## Notes of 2/15 MMC Site Plan Review Meeting (CMP/Detours)

Key points from the 2/15/18 Site Plan Review meeting with MMC:

### **Congress Street Closure and associated detours/emergency access (based on the revised docs and plans attached to this e-mail from Gorrill-Palmer)**

**CMP - East Tower and Visitor Garage (based on revised CMP as attached from Turners)**

General Notes:

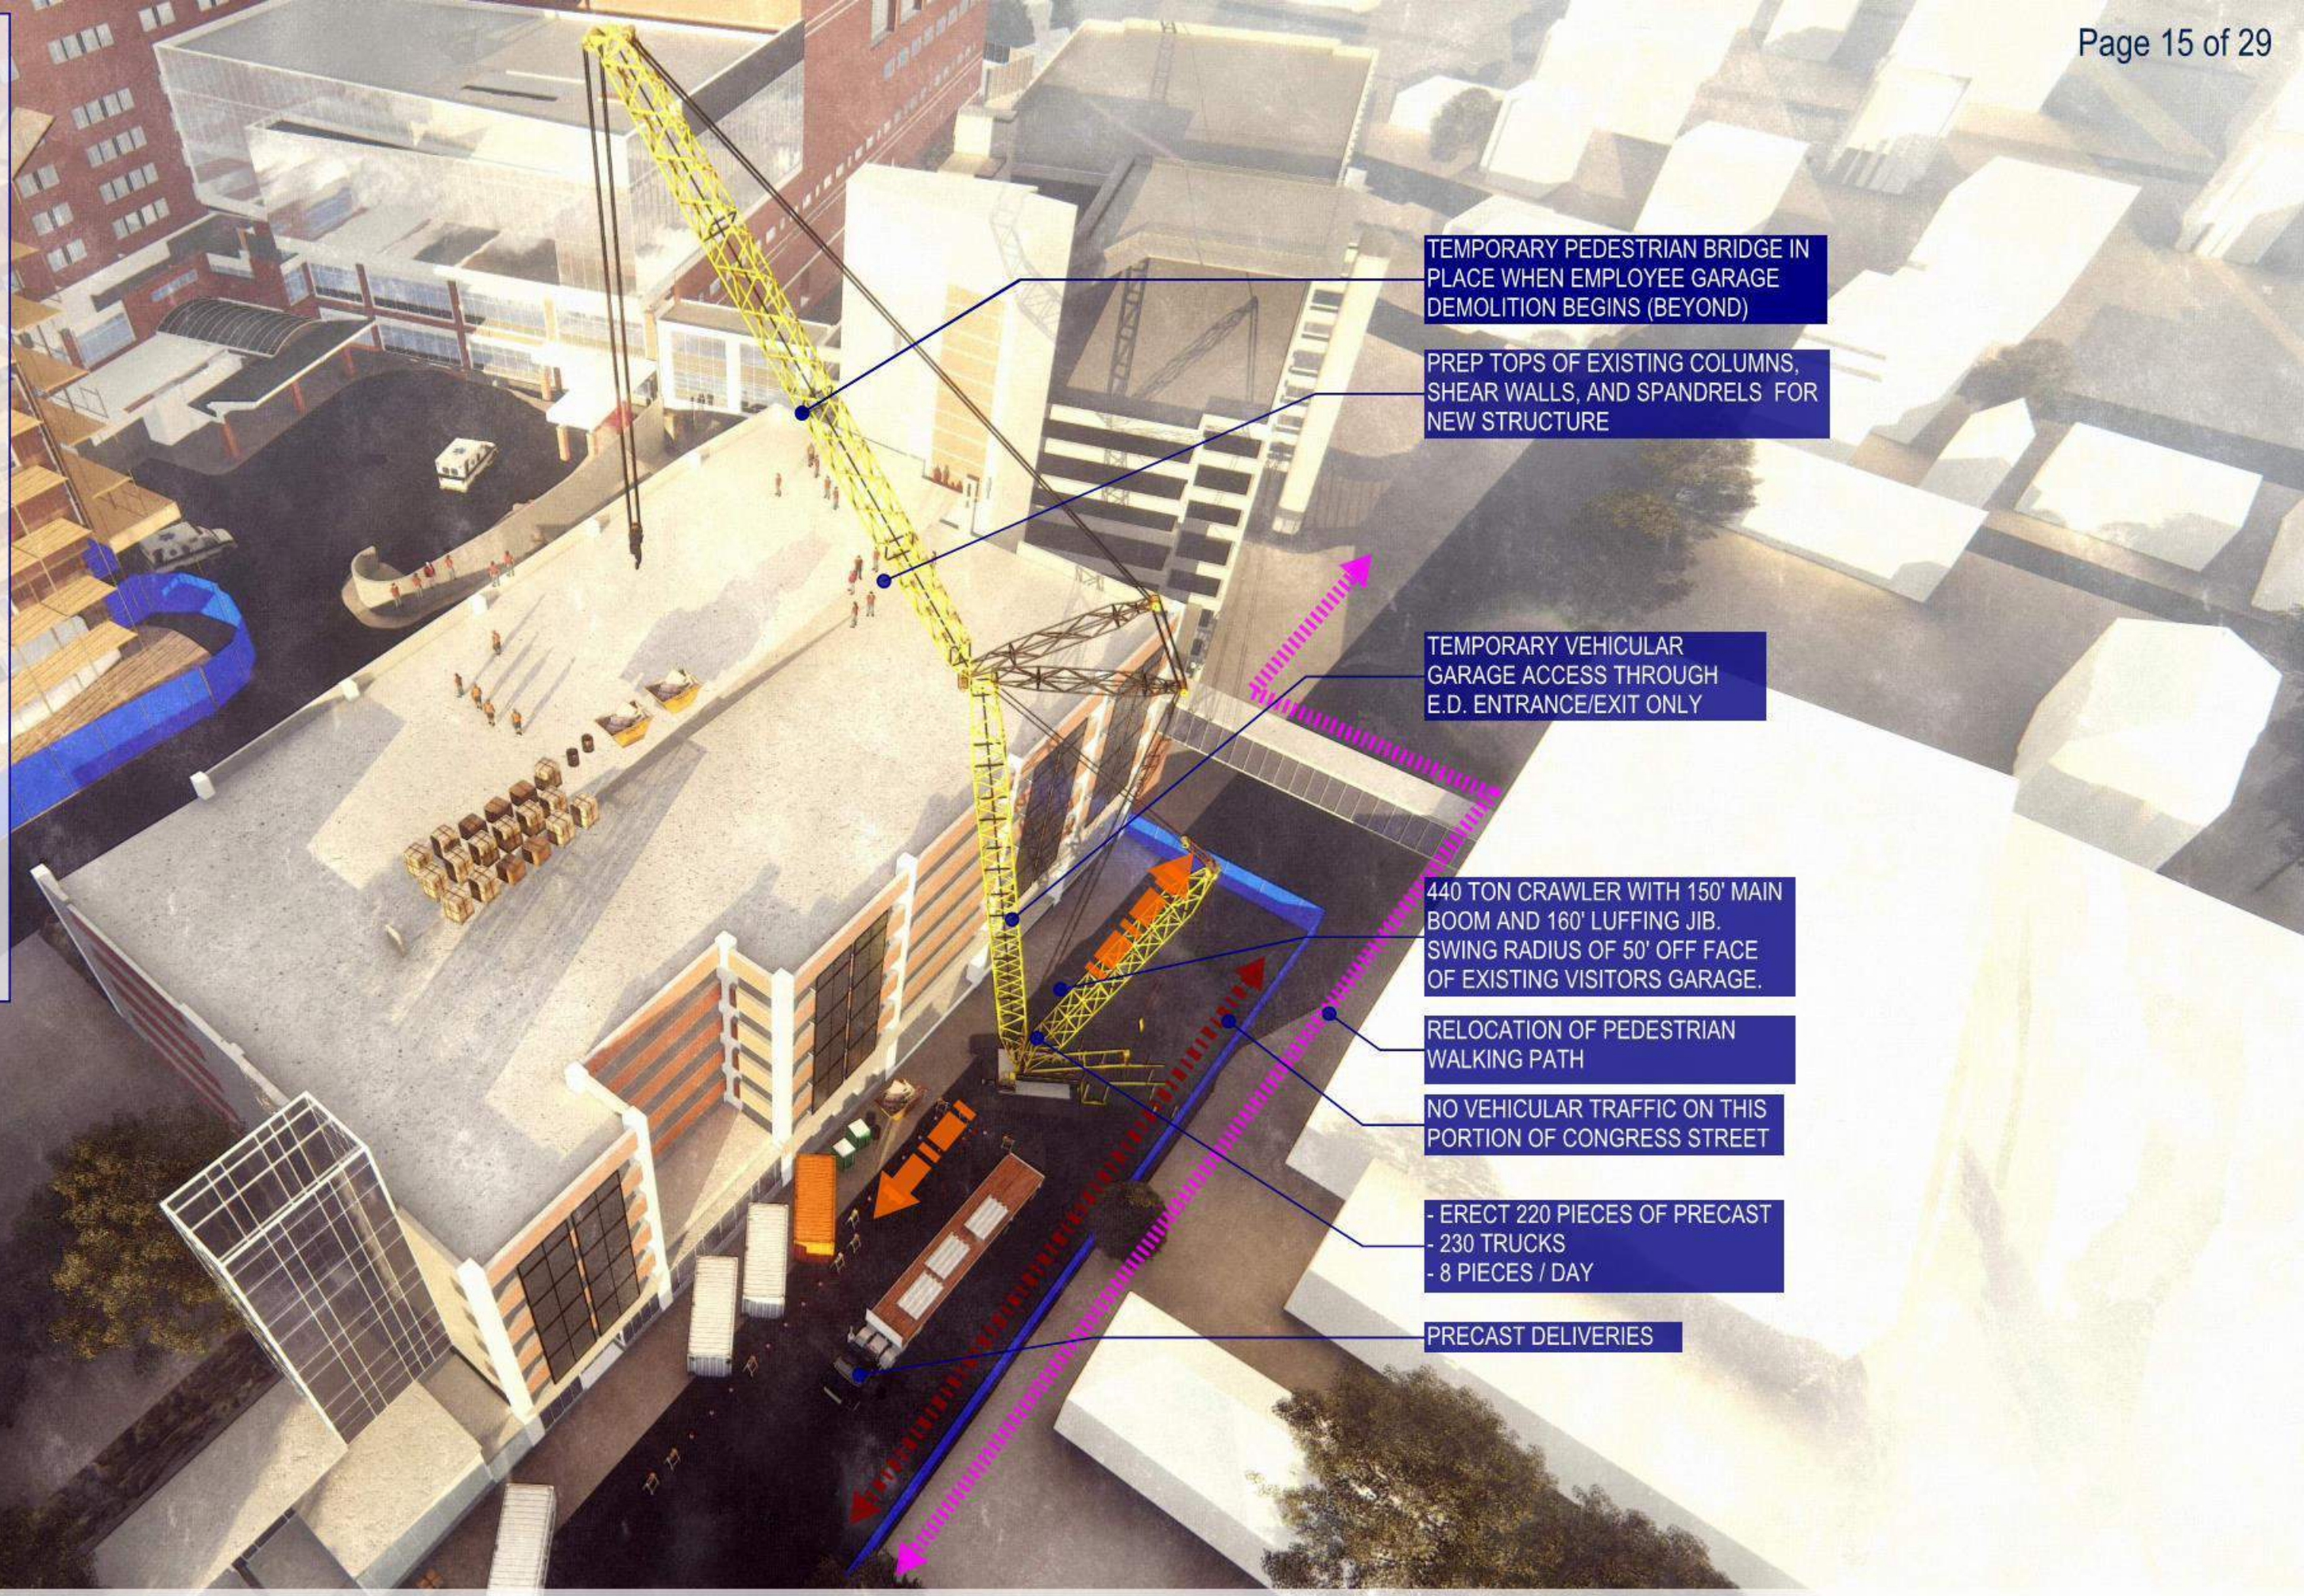
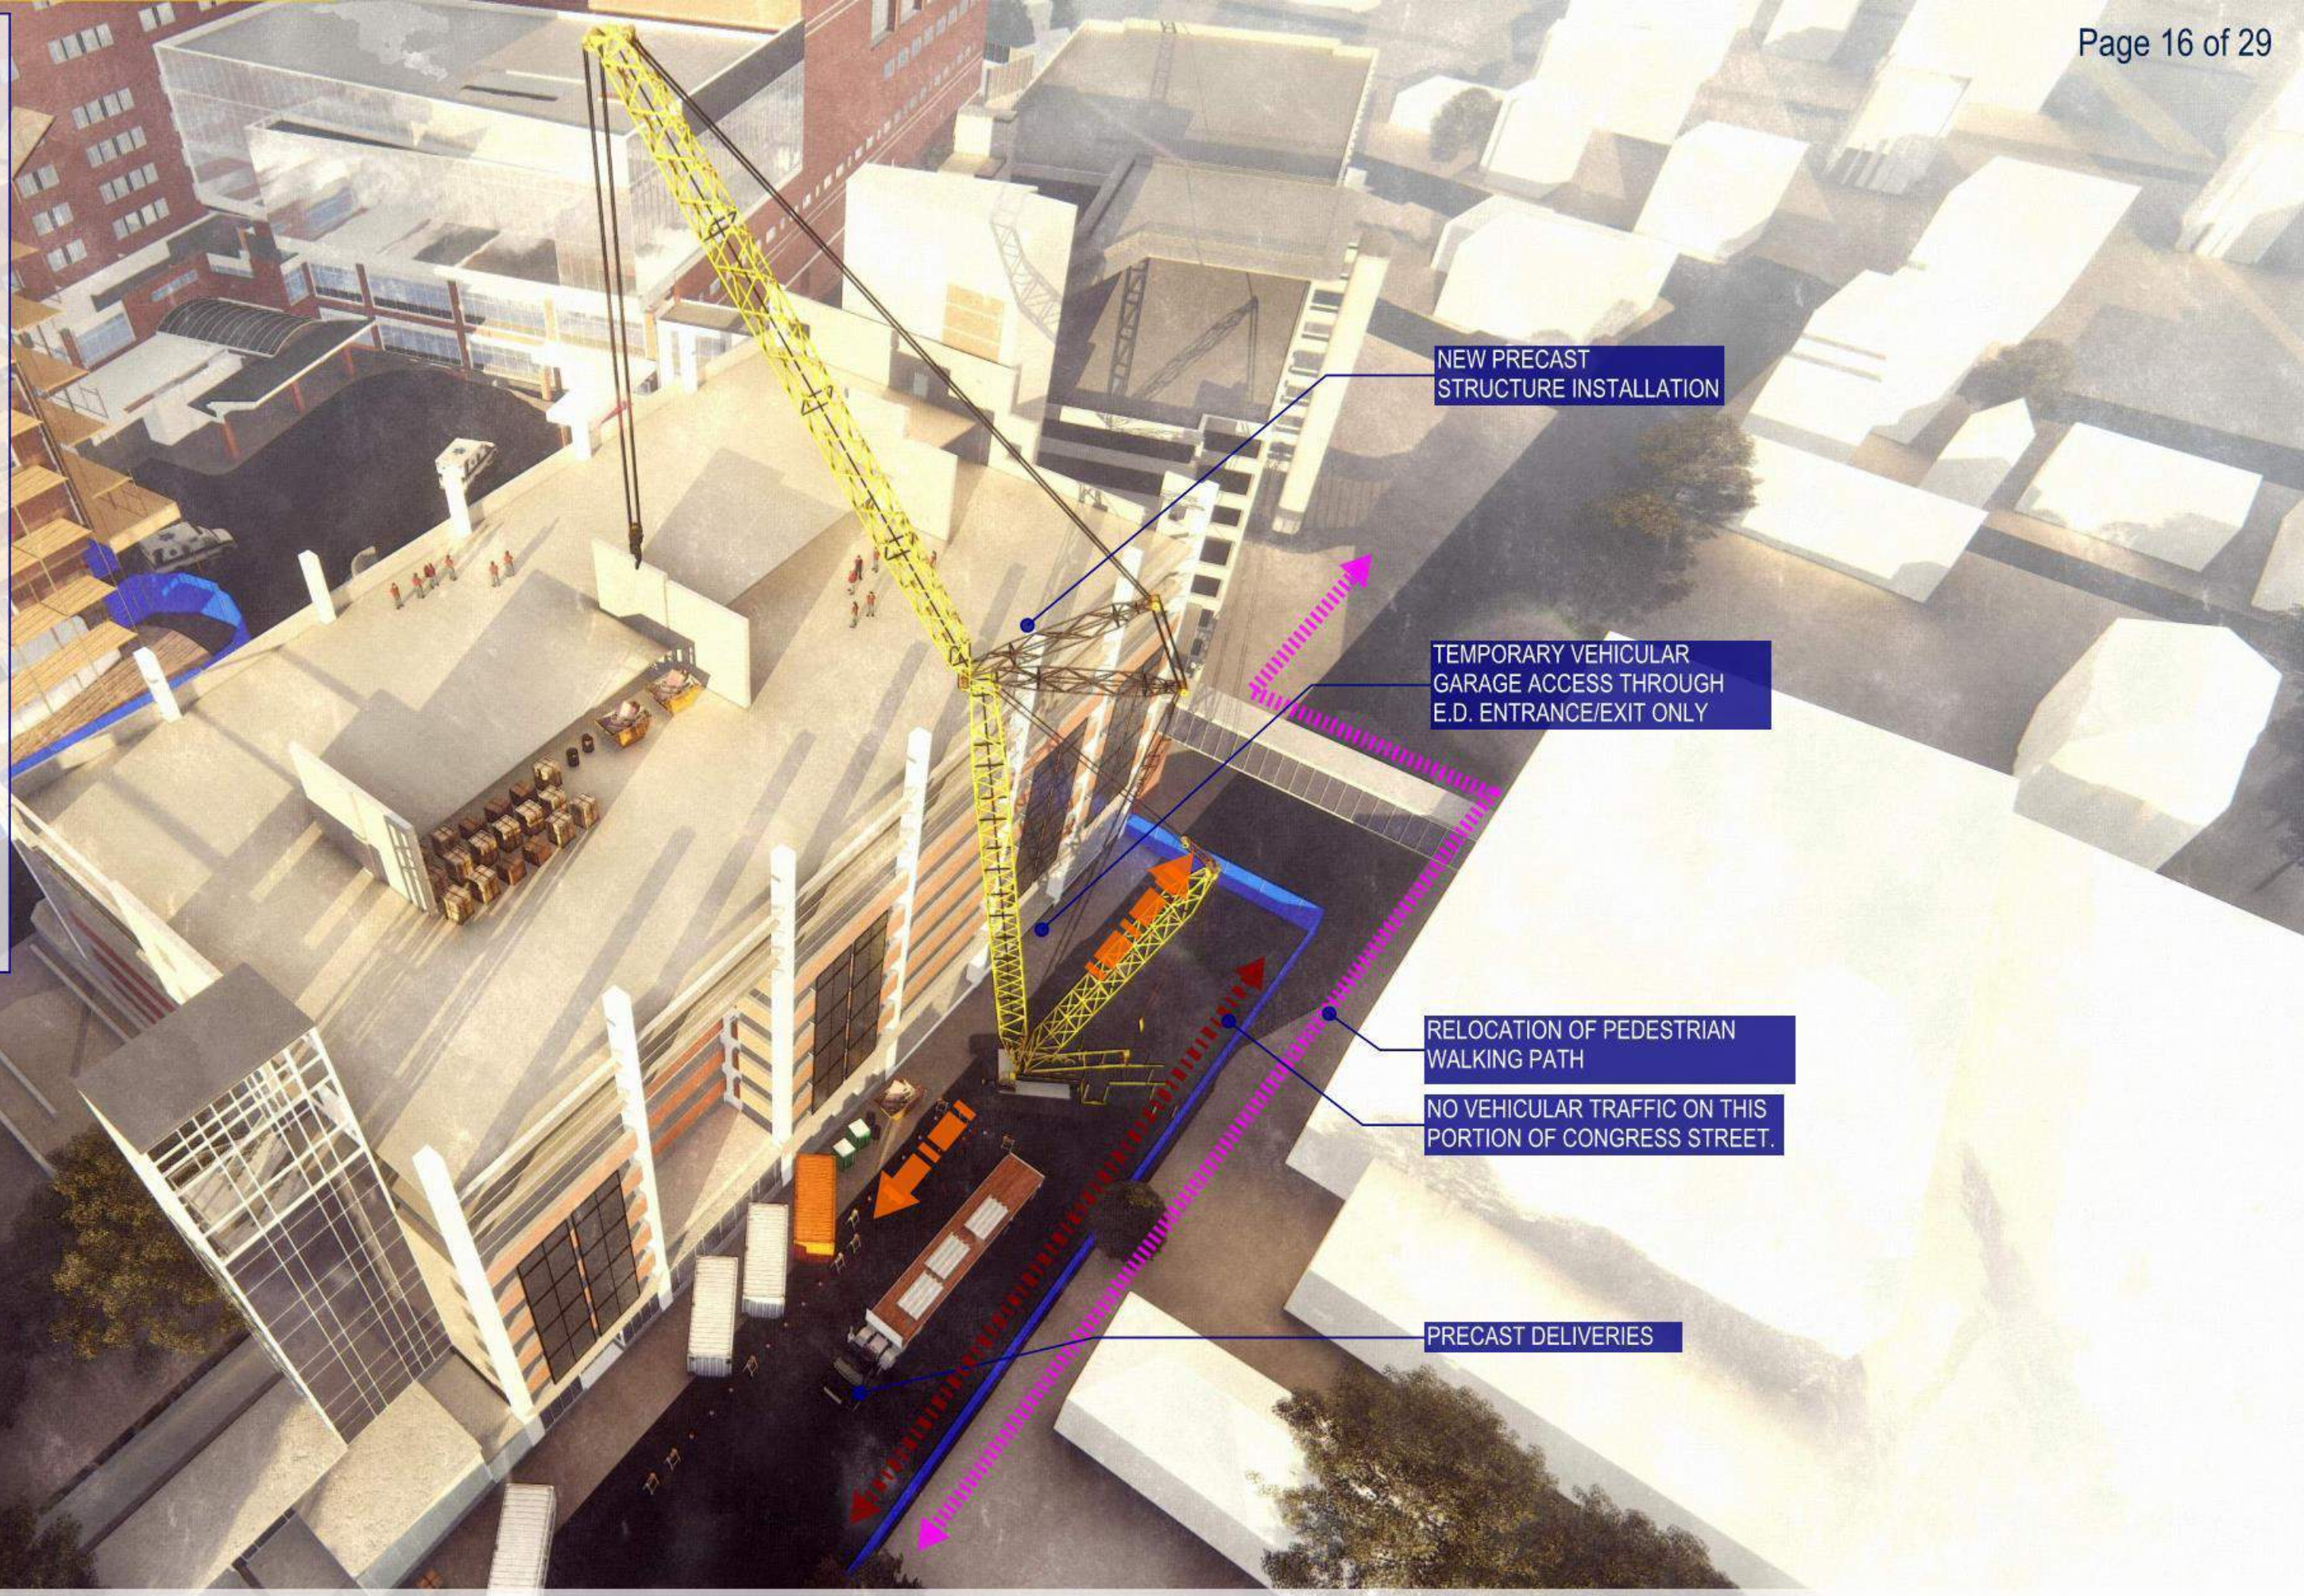
- Congress St closure anticipated May 7 to June 28 for the installation of precast beams for overbuild of the visitors garage - weather biggest factor
- Turner summarized the revisions to CMP, which included facilitating the ambulance access, adding delivery routes

- Concern re pedestrian route along Congress by construction area
  - Need ADA ramp
  - Need 9ft for crossing
  - Ensure entire sidewalk available

- Look at conflicts for peds crossing Weymouth at Congress - need to address
  - Gilman crosswalk needs to be ADA compliant
- Timetable (based on SO (Tuck) discussions with MMC and City Communication Directors)
  - - Need for early completion of telephone tree communication structure/contacts to be circulated within about 2 weeks and to be tested ahead by local and regional responders
  - - In week after 2/27 PB meeting need schedule that includes lead time and actions
  - - Early prep of handouts for employees and visitors plus early website info important
